**OXFORDSHIRE COUNTY COUNCIL'S RESPONSE TO CONSULTATION ON THE
FOLLOWING DEVELOPMENT PROPOSAL**

Application no: 13/01056/OUT

Proposal: OUTLINE - Up to 200 residential units, access, amenity space and associated works

Location: South Lodge Fringford Road Caversfield Bicester OX27 8TH

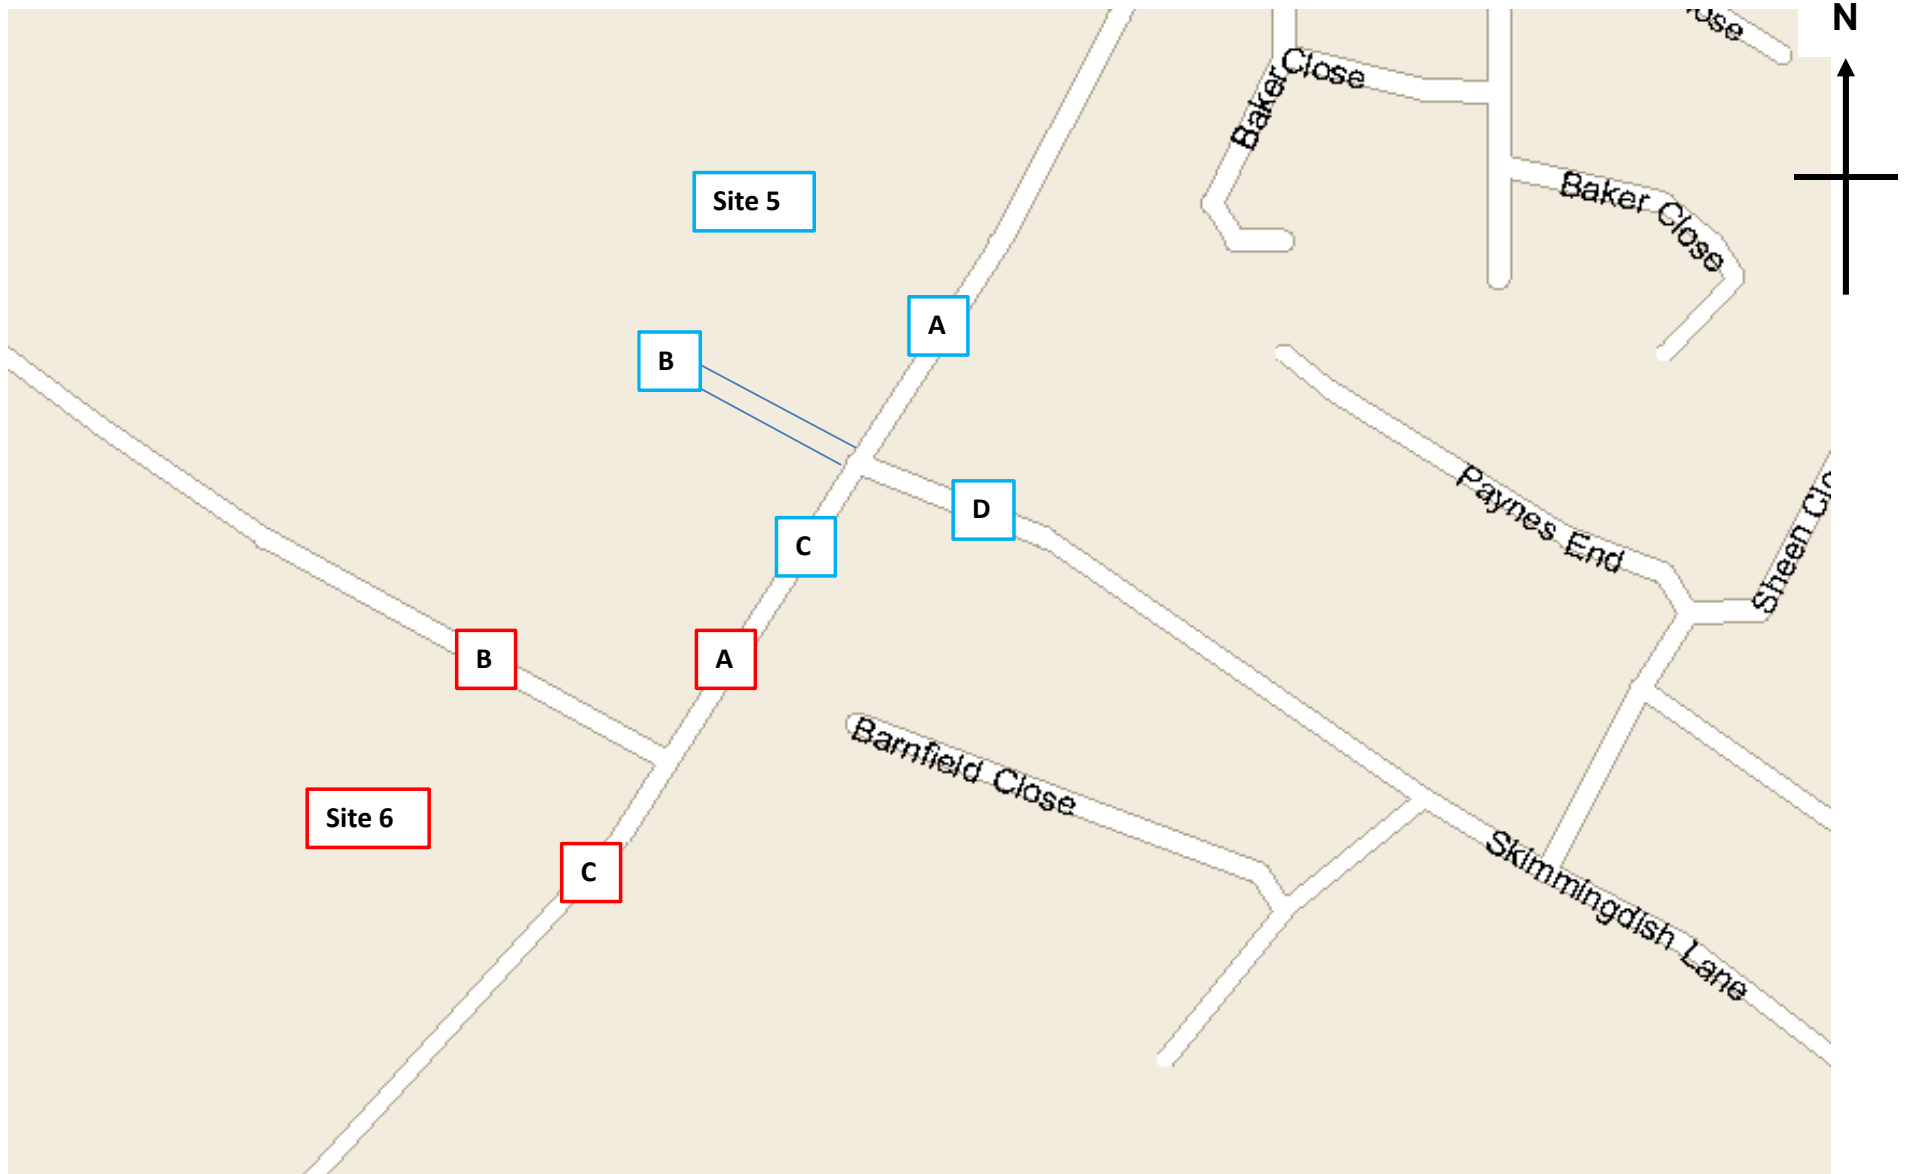
3. There is a substandard vision splay at the junction of Unnamed Road and Fringford Road south of the site. This development is likely to intensify vehicular use of this junction and may increase risk of road collisions due to lack of visibility of approaching vehicles at this junction.

I note from site visit that the visibility from the unnamed road to the south onto Fringford Road is substandard. Given that the proposal is likely to intensify vehicular use of the unnamed road, this is a concern. **(Concern – visibility at unnamed road/ Fringford Road junction)**

**Existing Junction Arrangement**

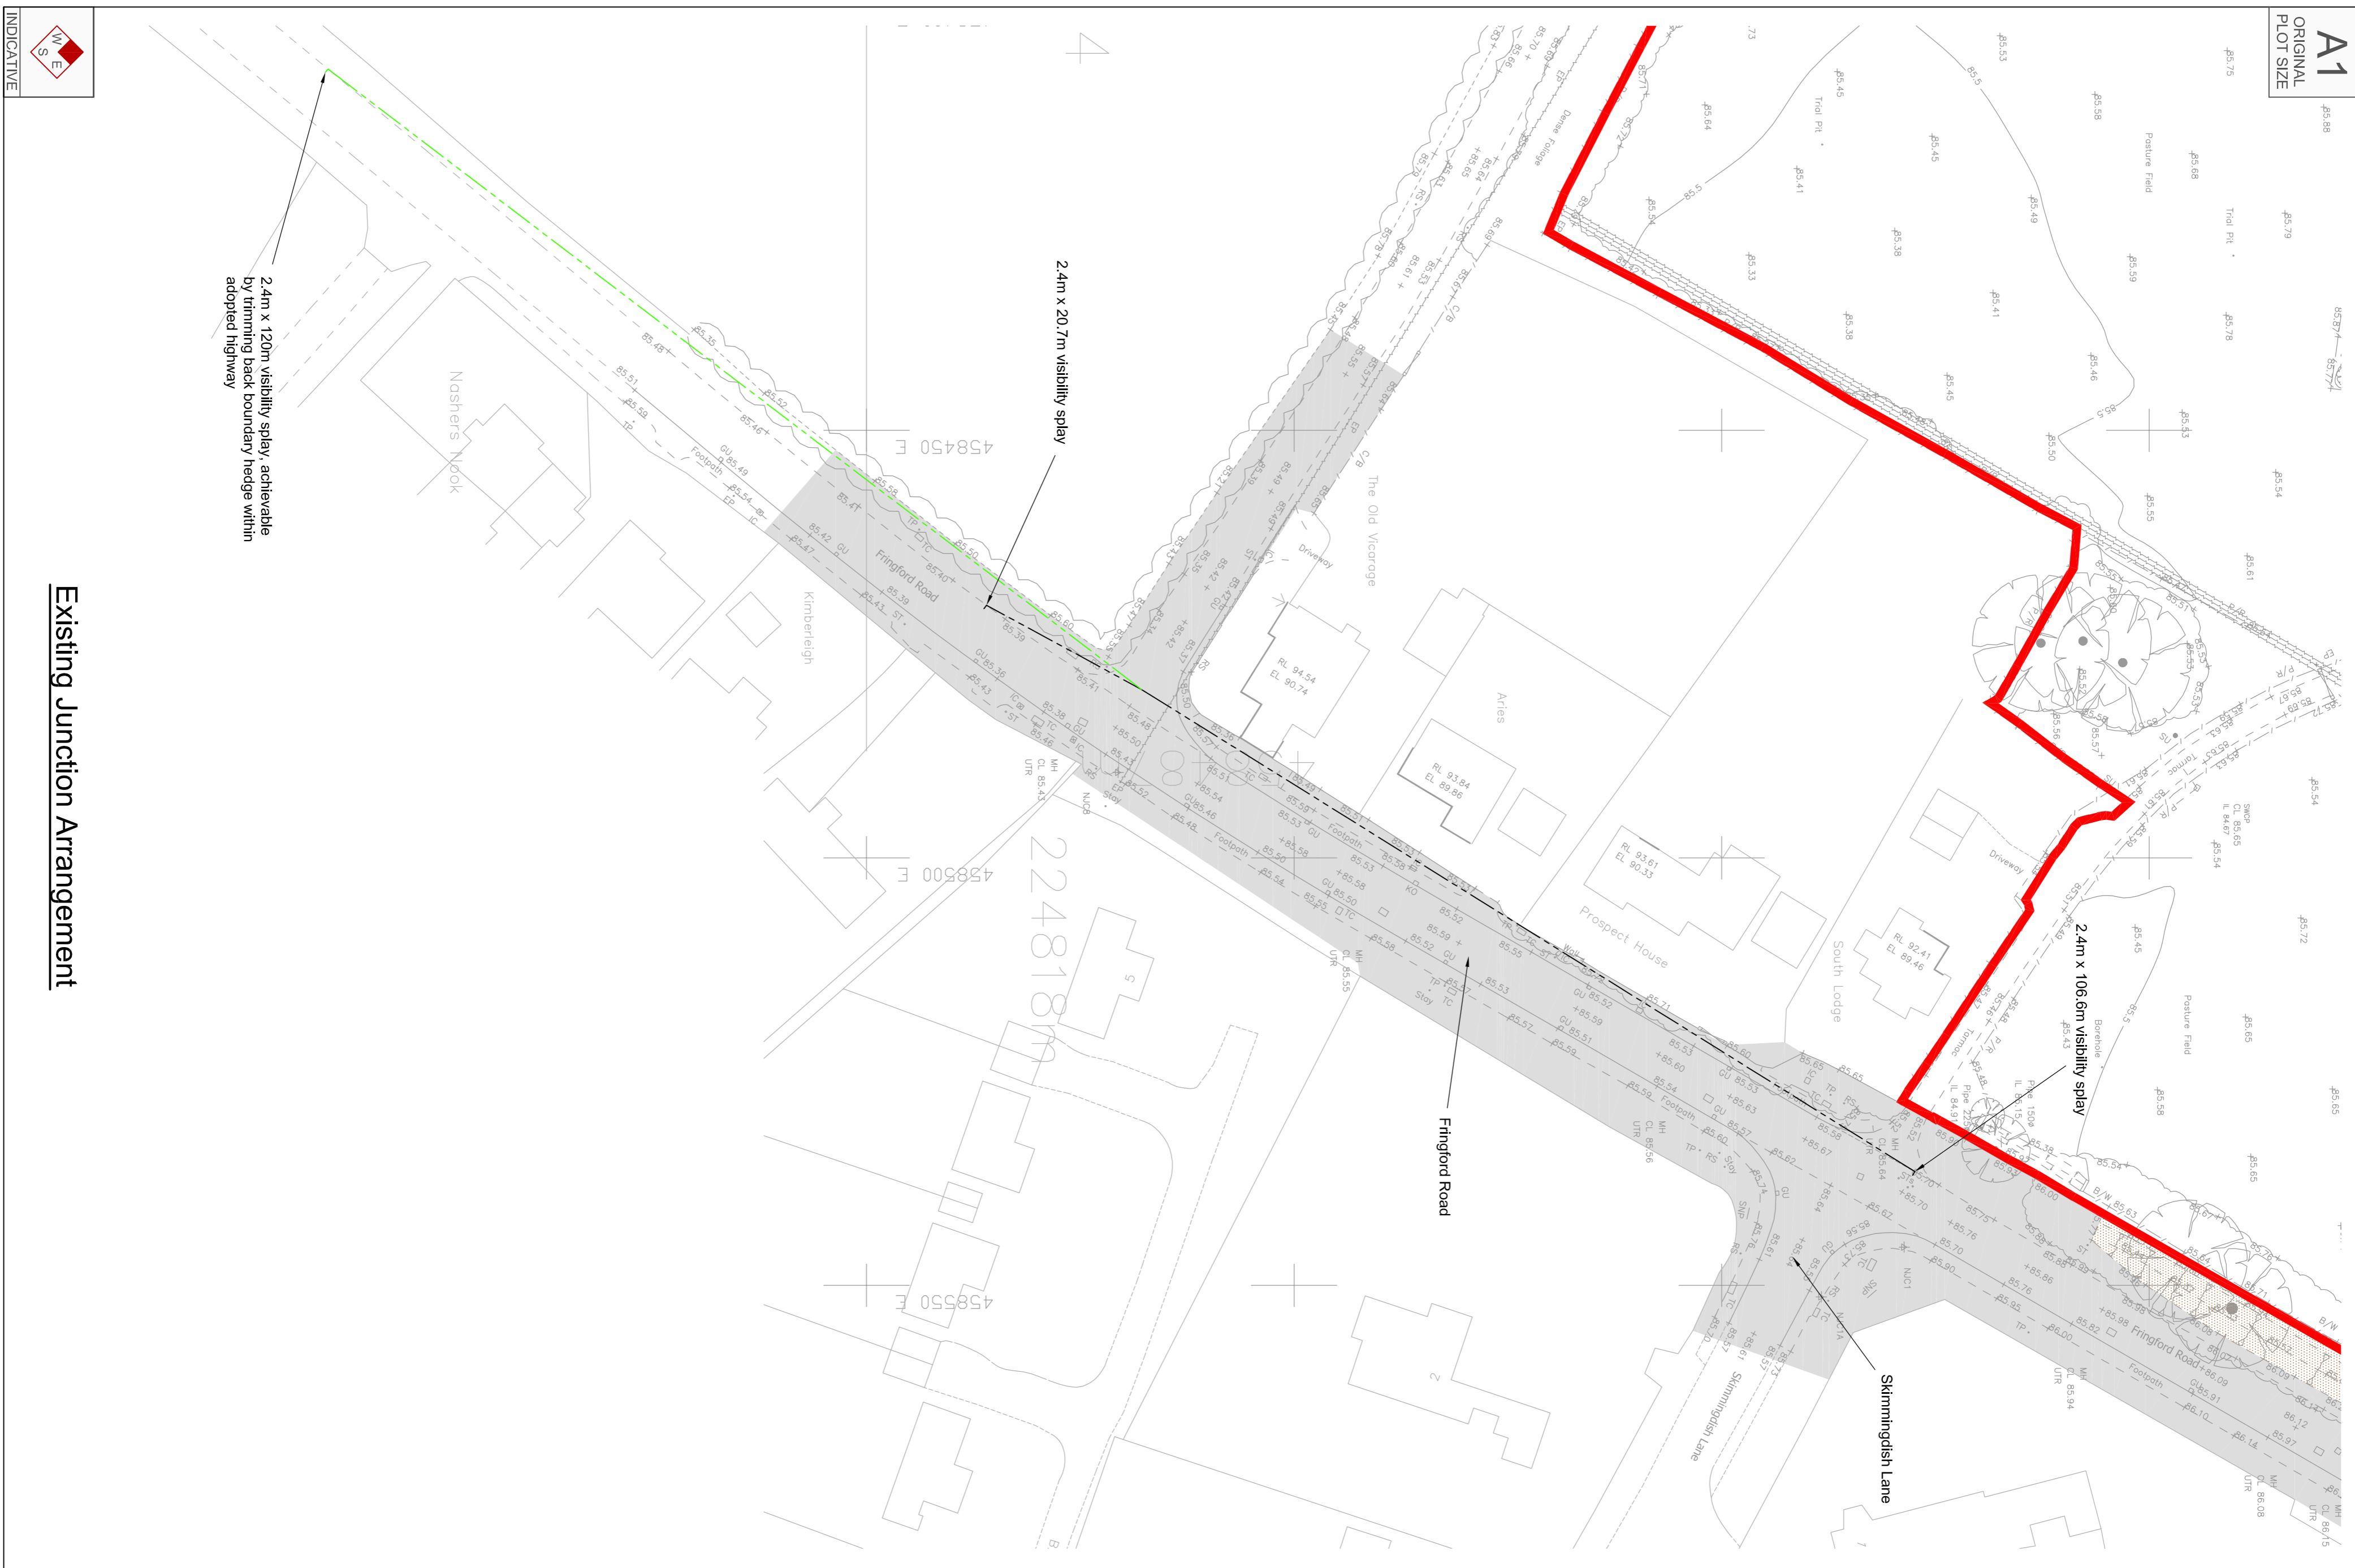
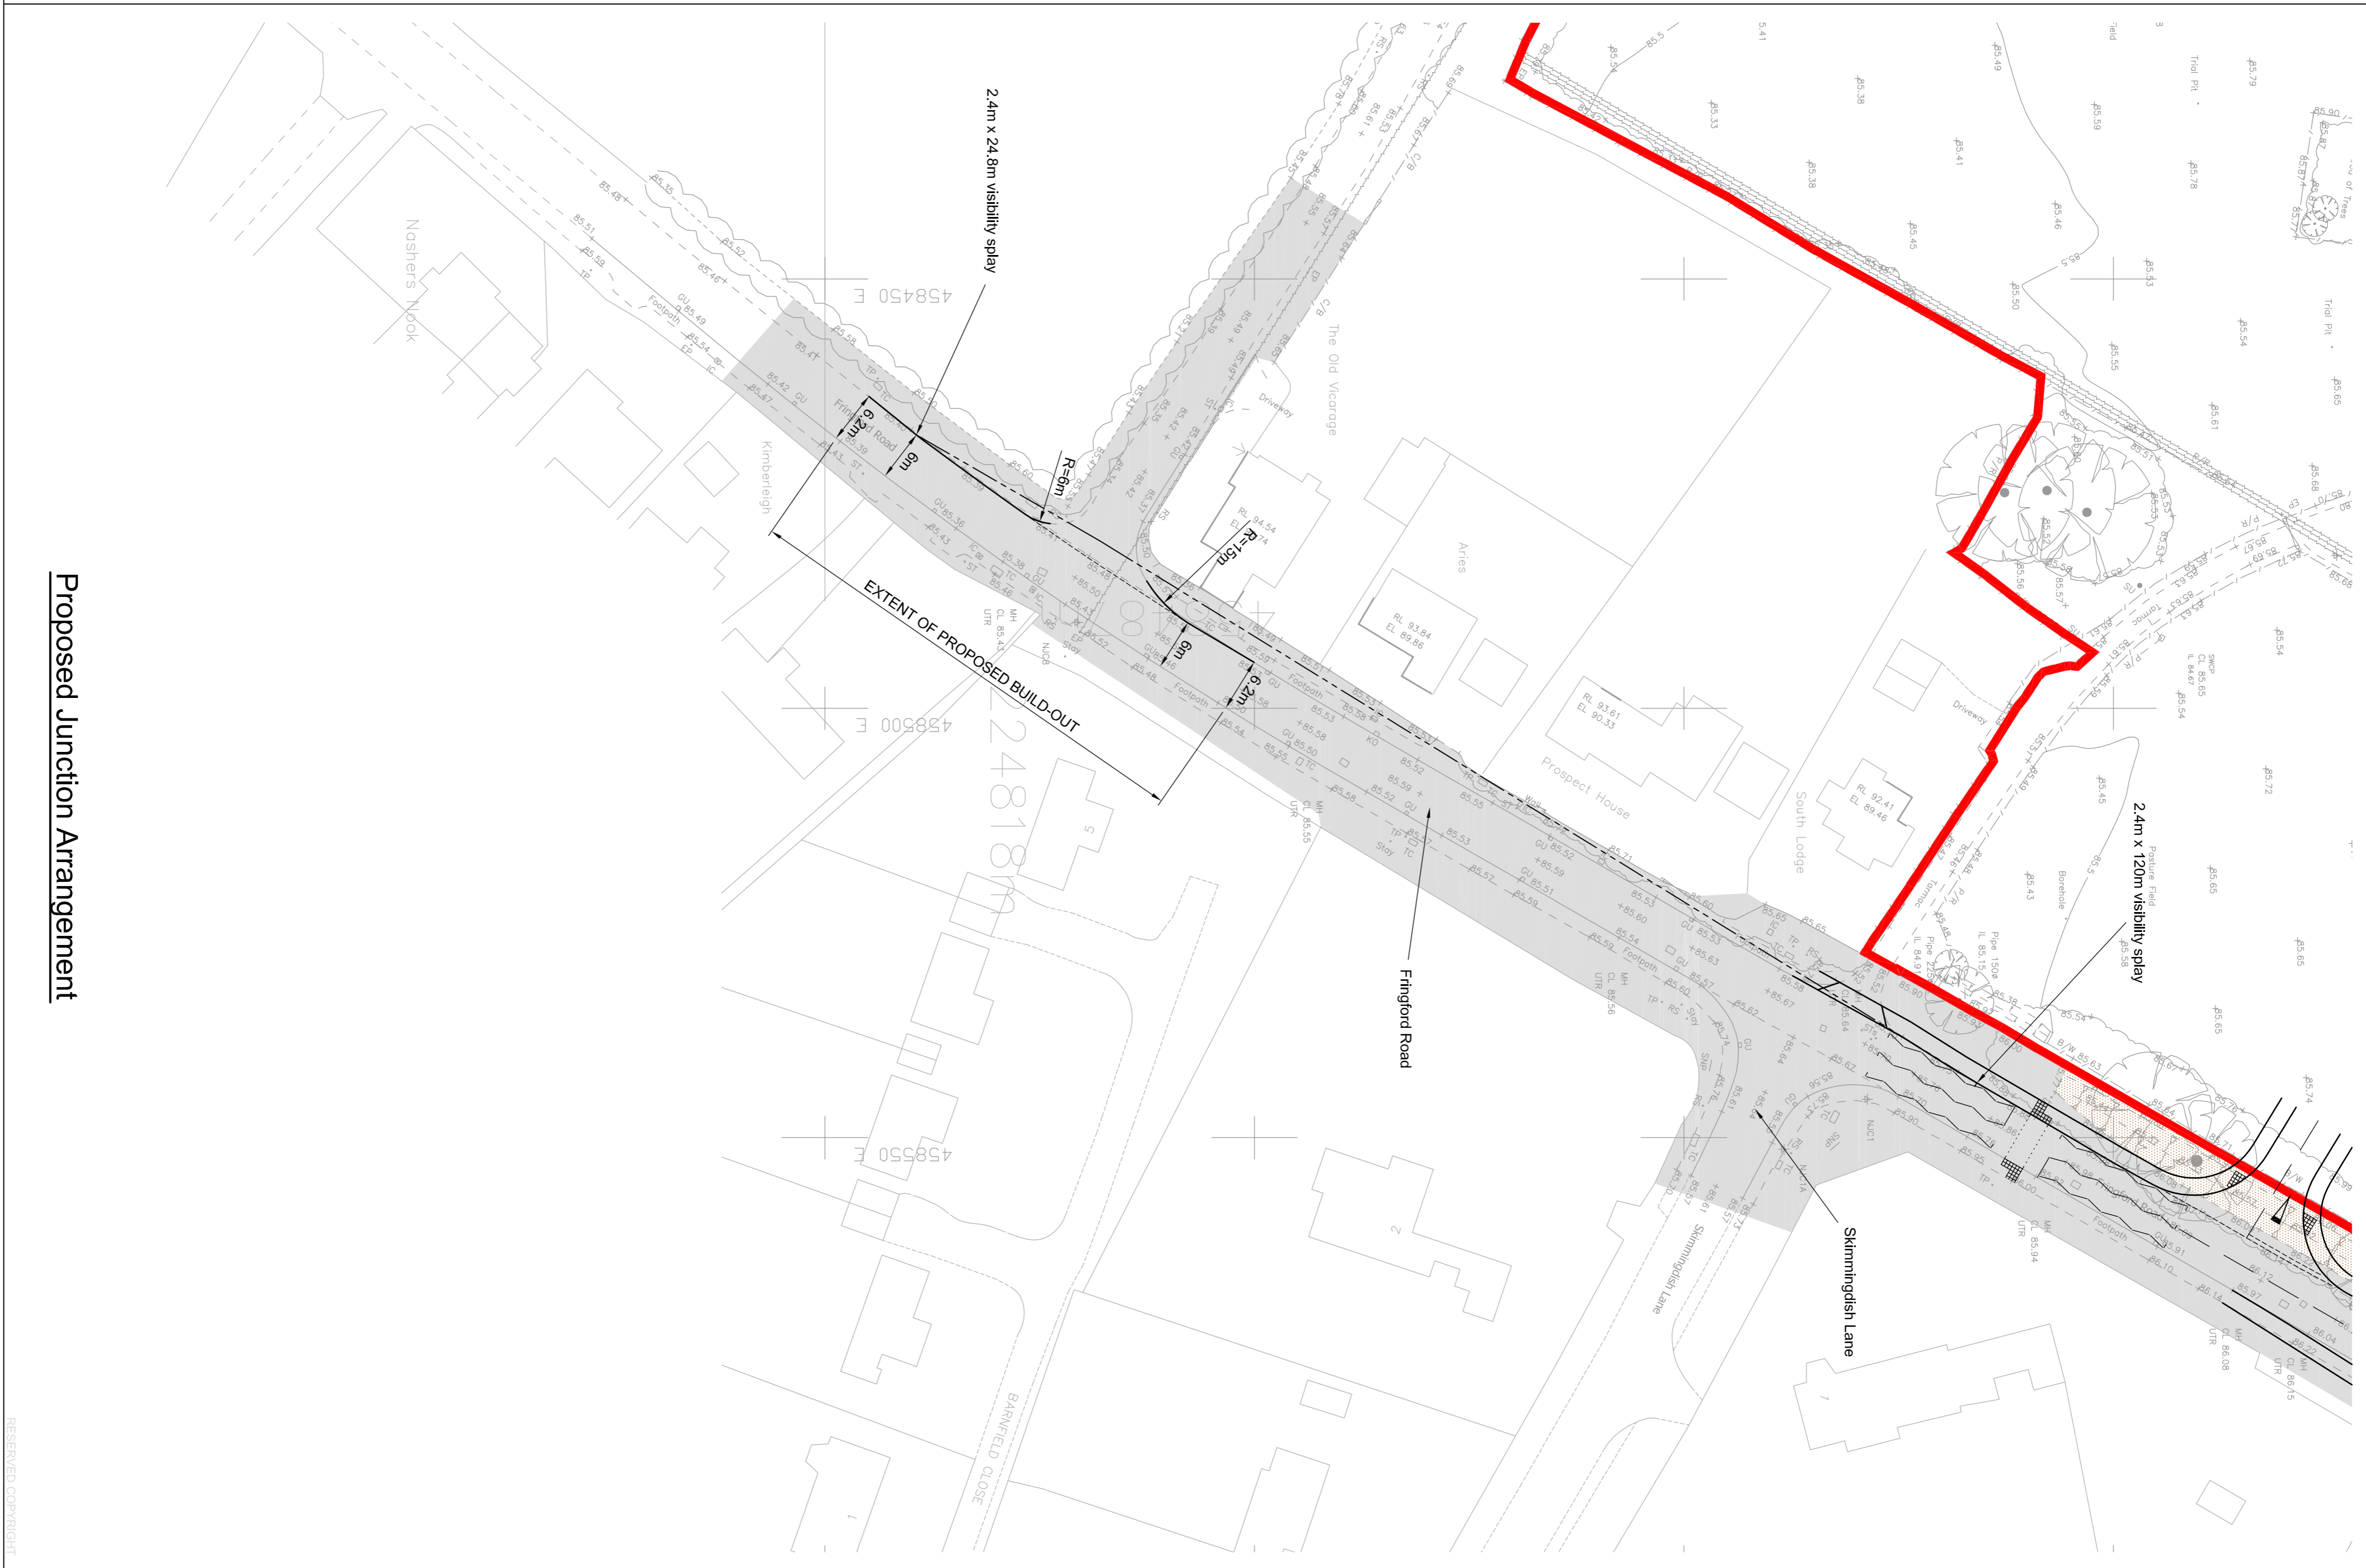
- **Highway safety concerns**, including:
 1. An adequate, safe highway access for the site has not been demonstrated. It is unclear whether the required access vision splay can be achieved within land owned or controlled by the applicant.

The application proposes a new vehicular access onto Fringford Road. The detail of this proposed access, including visibility splays, has not been submitted for consideration and approval. Vision splays of 2.4m x 120m will be required, provided that the 85th percentile speed of traffic in the vicinity is 40mph in line with the local speed limit. Such a vision splay would extend past the applicant's red-line application boundary, and would likely necessitate the removal of third party trees and vegetation to the north of the site. It has not been demonstrated that a safe, adequate access to the public highway can be achieved. **(Concern – highway safety)**
